CHECKLIST RESPONSES: HEADRICK RESIDENCE PHASE 2
Intake Screening - 2202-128 – Incomplete – 8822 SE 62ND ST, MERCER ISLAND

INTAKE COMMENTS PLANNING		Reviewer	Lauren Anderson	
		Email	Lauren.Anderson@mercerisland.gov	
		Status	Not Accepted – Resubmit Entire Submittal Package for Reviewer App	
Land Use actions Required				
<input type="checkbox"/>	Shoreline Permit			
<input type="checkbox"/>	Critical Area Review 1			
<input type="checkbox"/>	Critical Area Review 2			
1	<input checked="" type="checkbox"/>	Environmental Review (SEPA Checklist)		
	<input type="checkbox"/>	Accessory Dwelling Unit (ADU)		
	<input type="checkbox"/>	Lot Line Revision		
	<input type="checkbox"/>	Other		
Surveys Required Prior to Final Inspection				
	<input type="checkbox"/>	A building height survey is required prior to final inspection		
2	<input checked="" type="checkbox"/>	An impervious surface, lot coverage, and or hardscape survey is required prior to final inspection		
3	<input checked="" type="checkbox"/>	A property line/setback survey is required prior to final inspection

SHEET:
A2.2

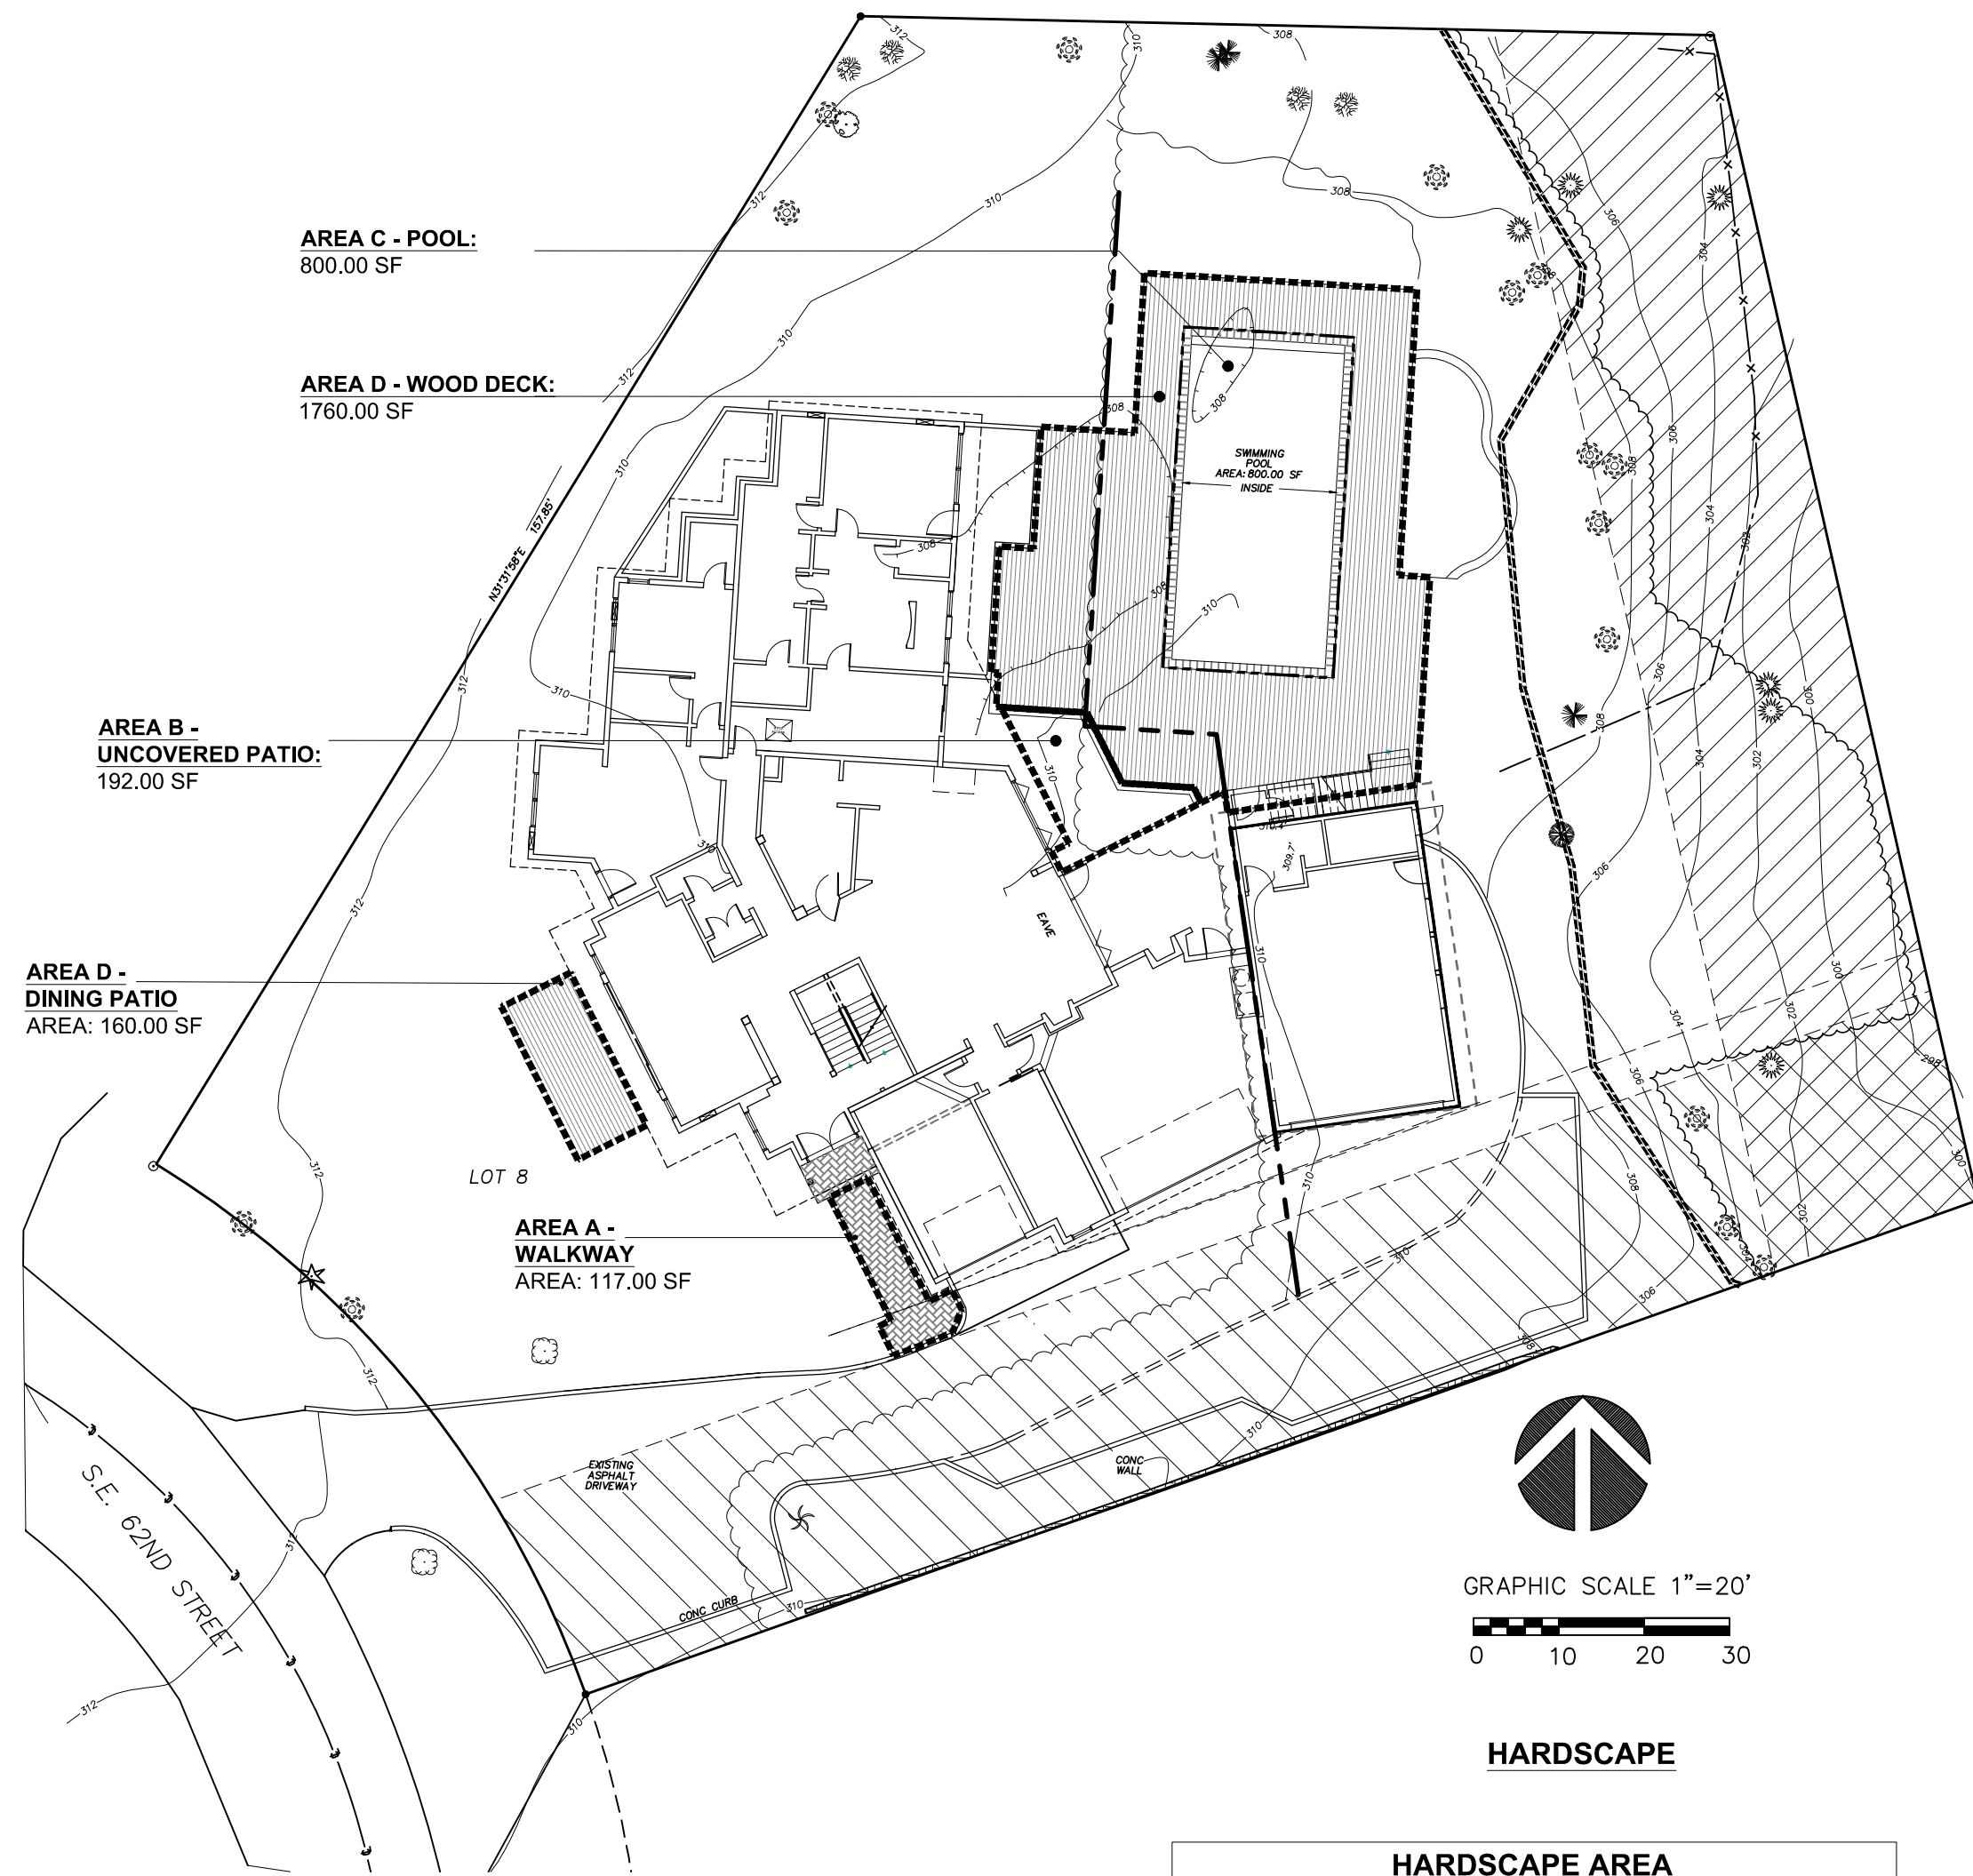
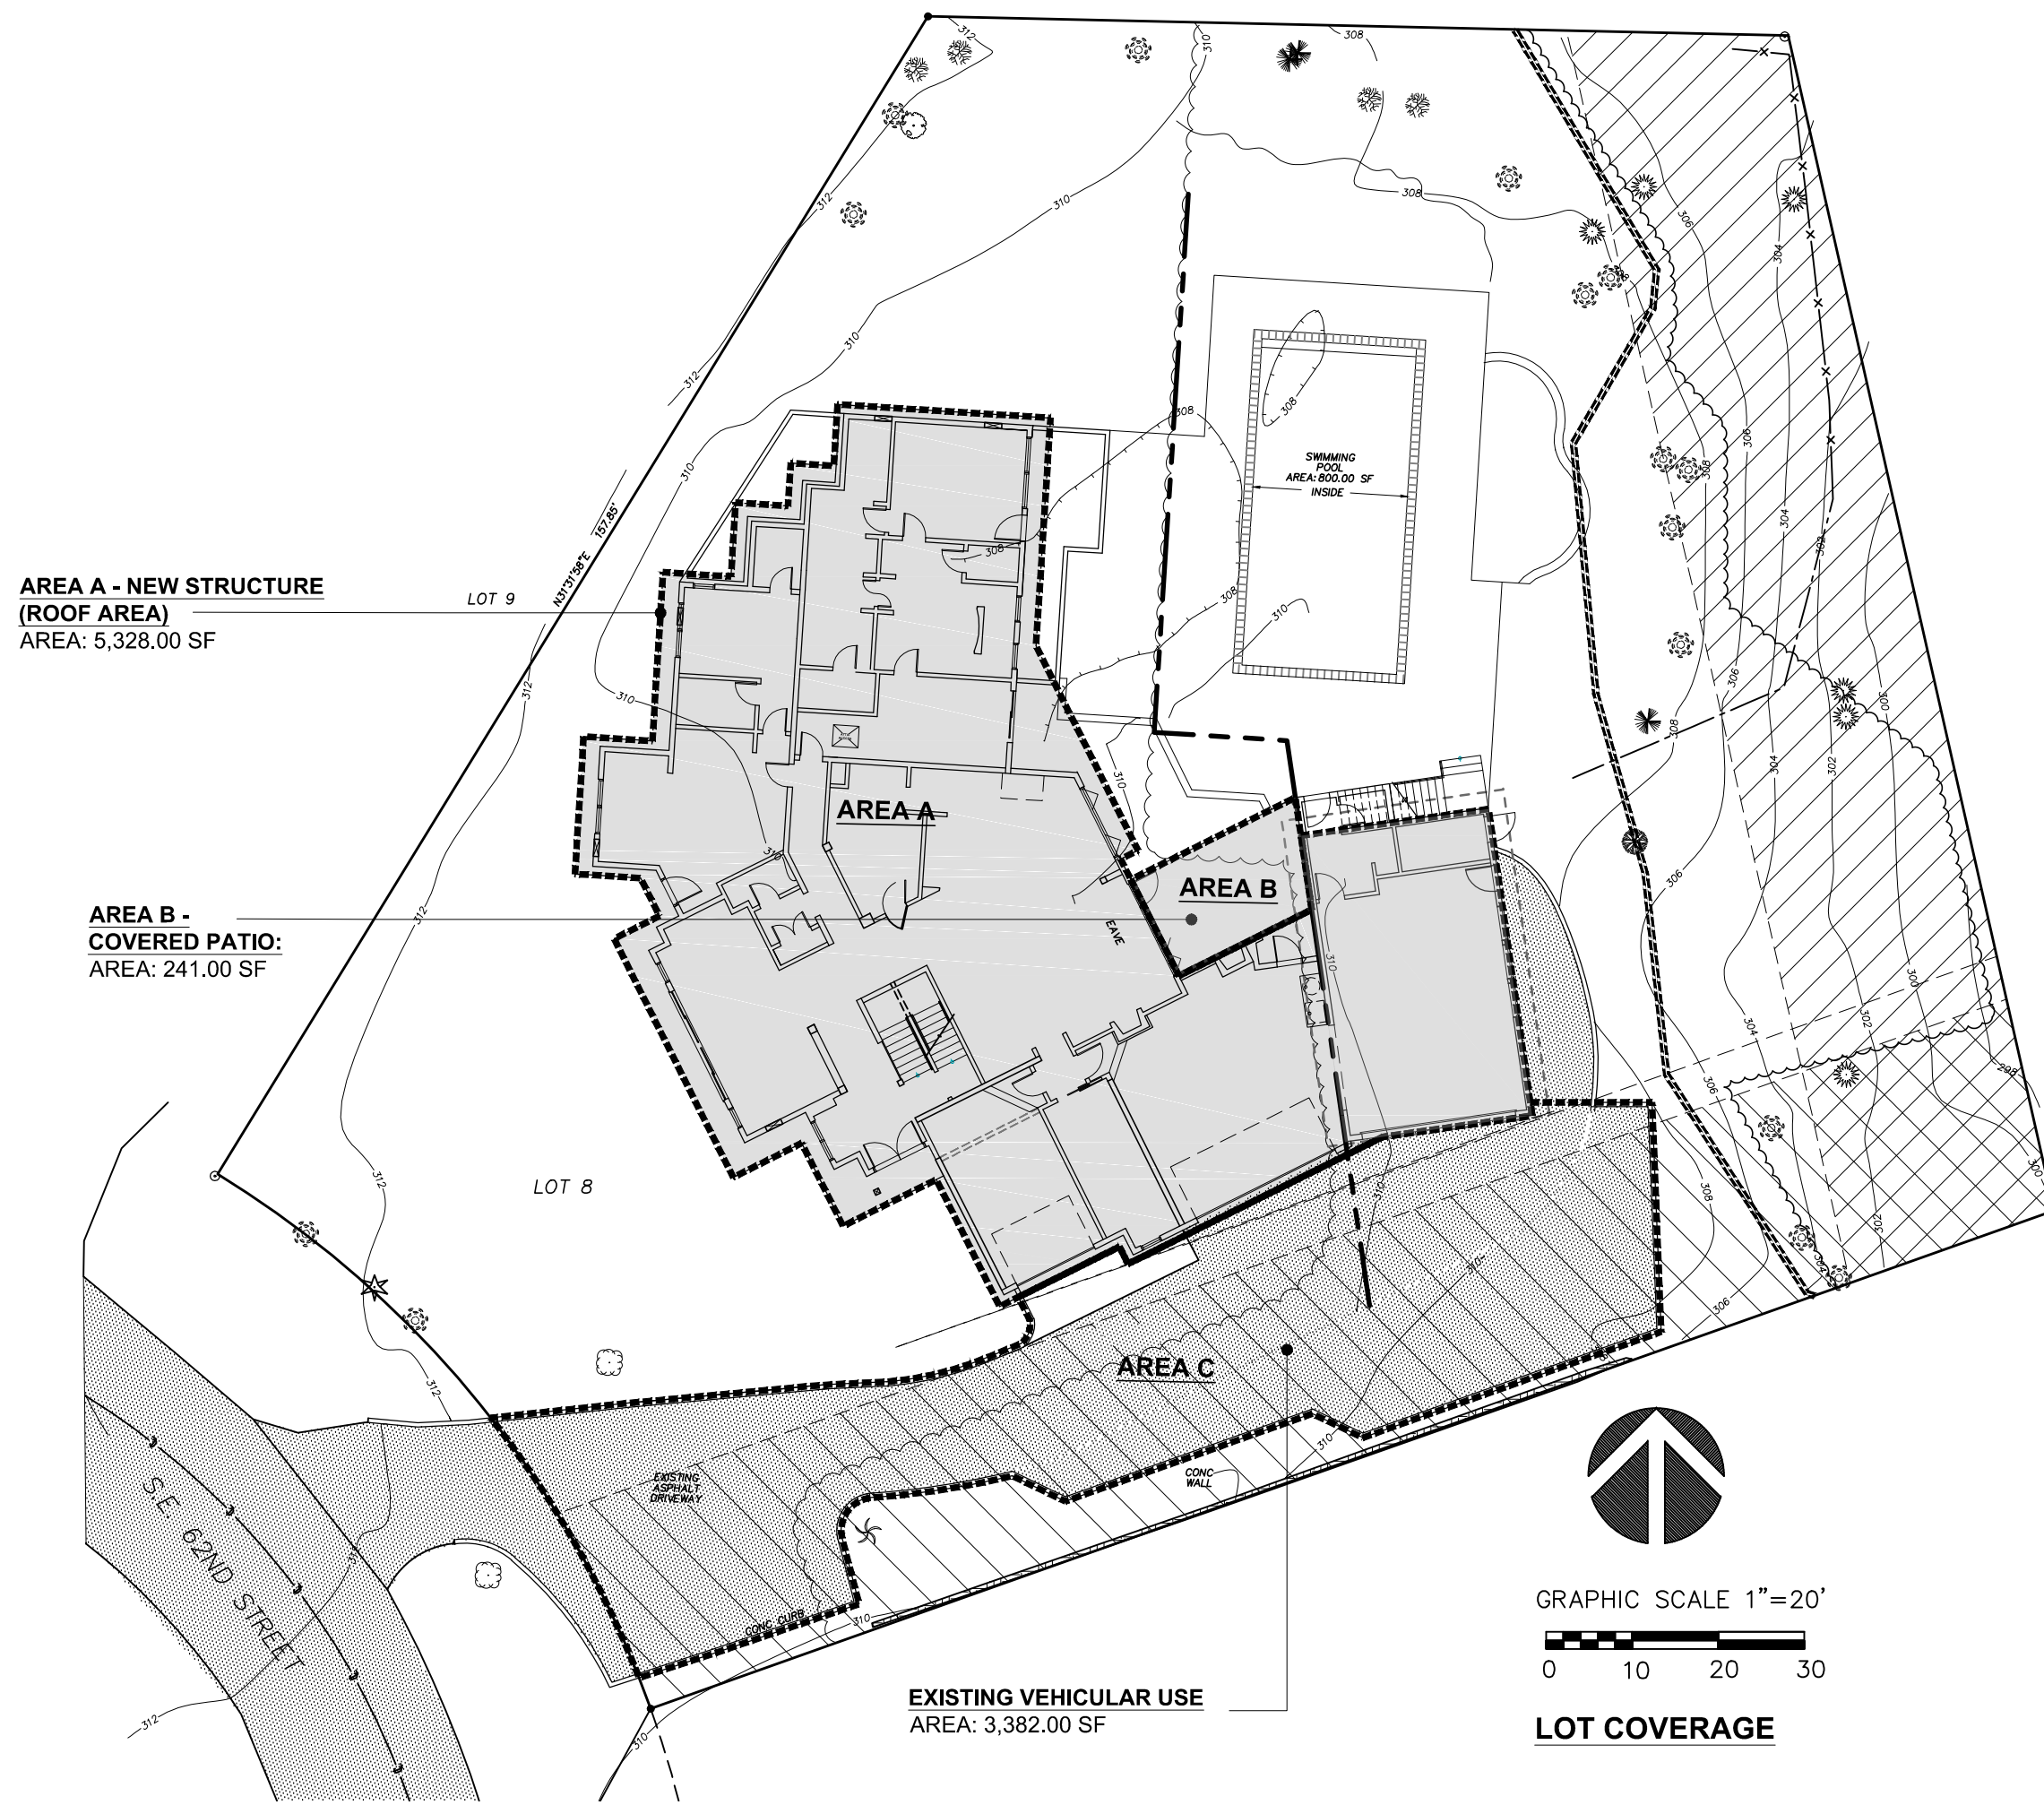
(8) Lot coverage, hardscape, and GFA calculations: See sheet A2.2

(14) The partial basement is fully below grade, and surrounded by new foundation crawl space. See schematic on sheet A2.2
